re: Grading & Servicing Plan Review
Proposed Multi-Storey Building
3745 St. Joseph Boulevard – Ottawa, Ontario
to: Sarah & Lenard Sémajuste – ssemajuste@gmail.com
date: August 30, 2023
file: PG6589-MEMO.02

Grading Plan Review

Site Servicing Plan Review

1 SITE SERVICING PLAN
1:250

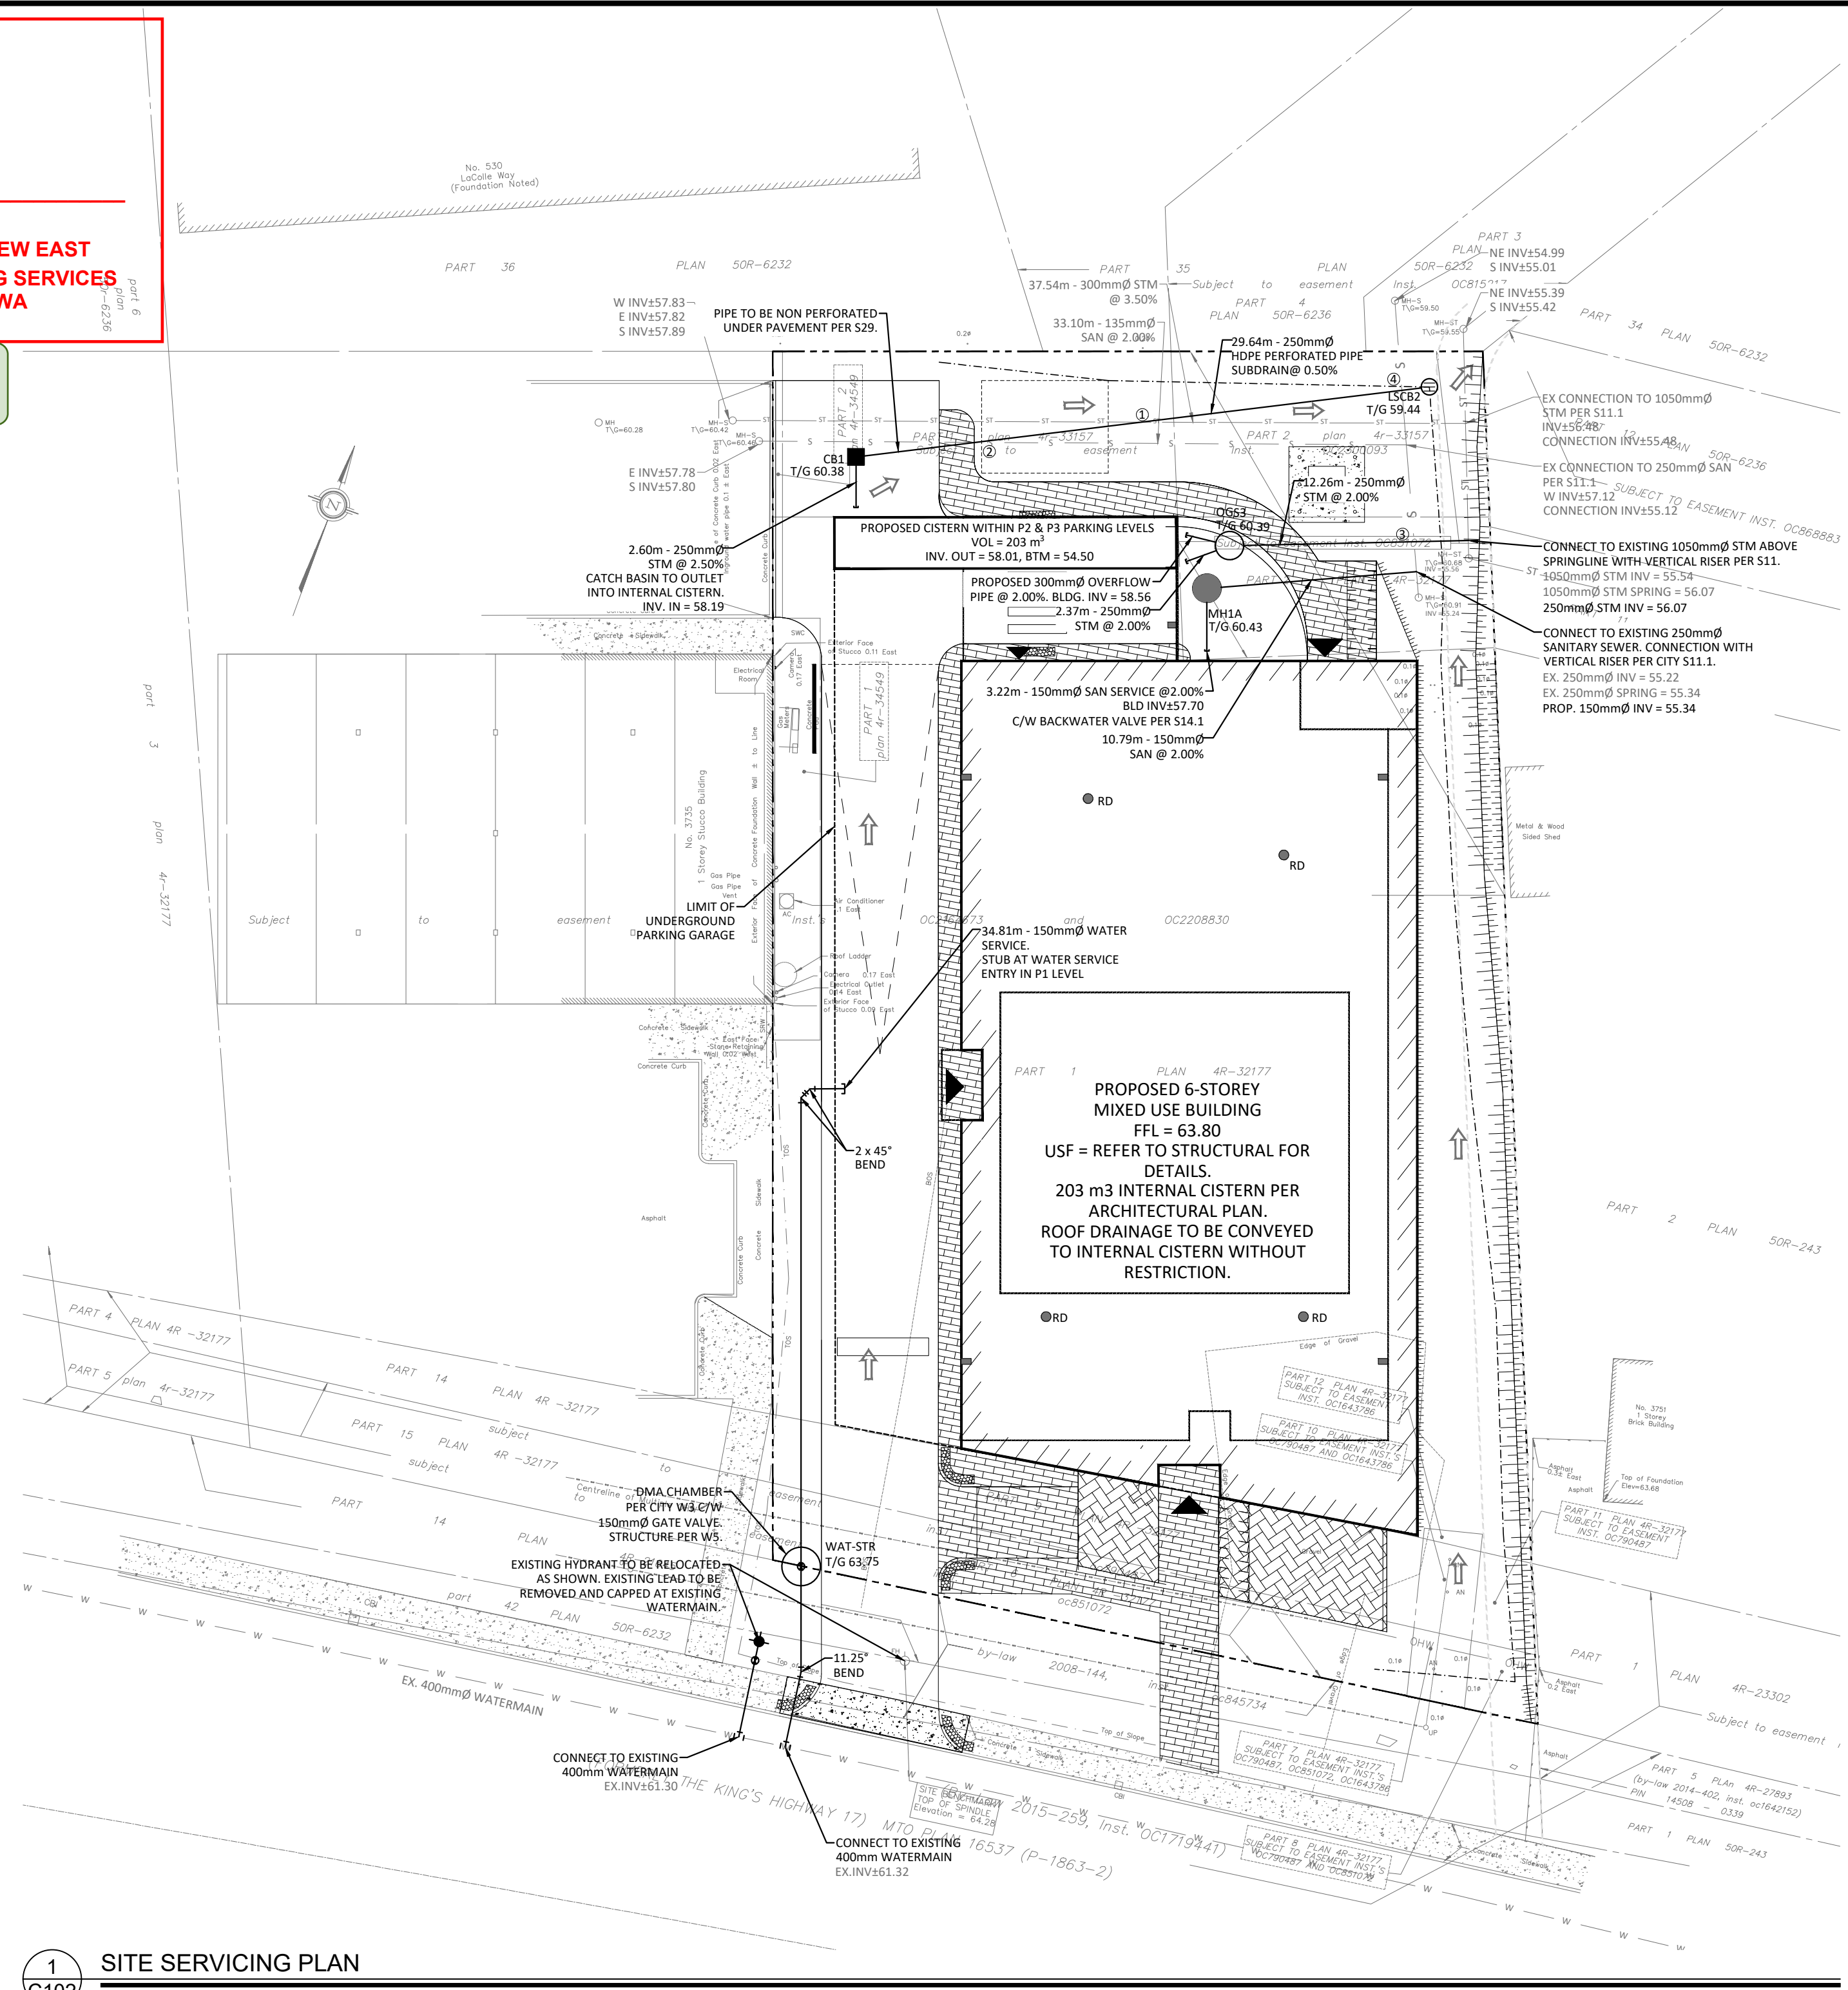
- Site Servicing Plan – 3745 St. Joseph Boulevard – Project No. CCO-23-3287 – Drawing No. C102 - Revision 1 dated May 12, 2023.

In reviewing this site servicing plan, sufficient soil cover has been provided to the proposed services. Therefore, no insulation of the servicing pipes is required, from a geotechnical perspective.
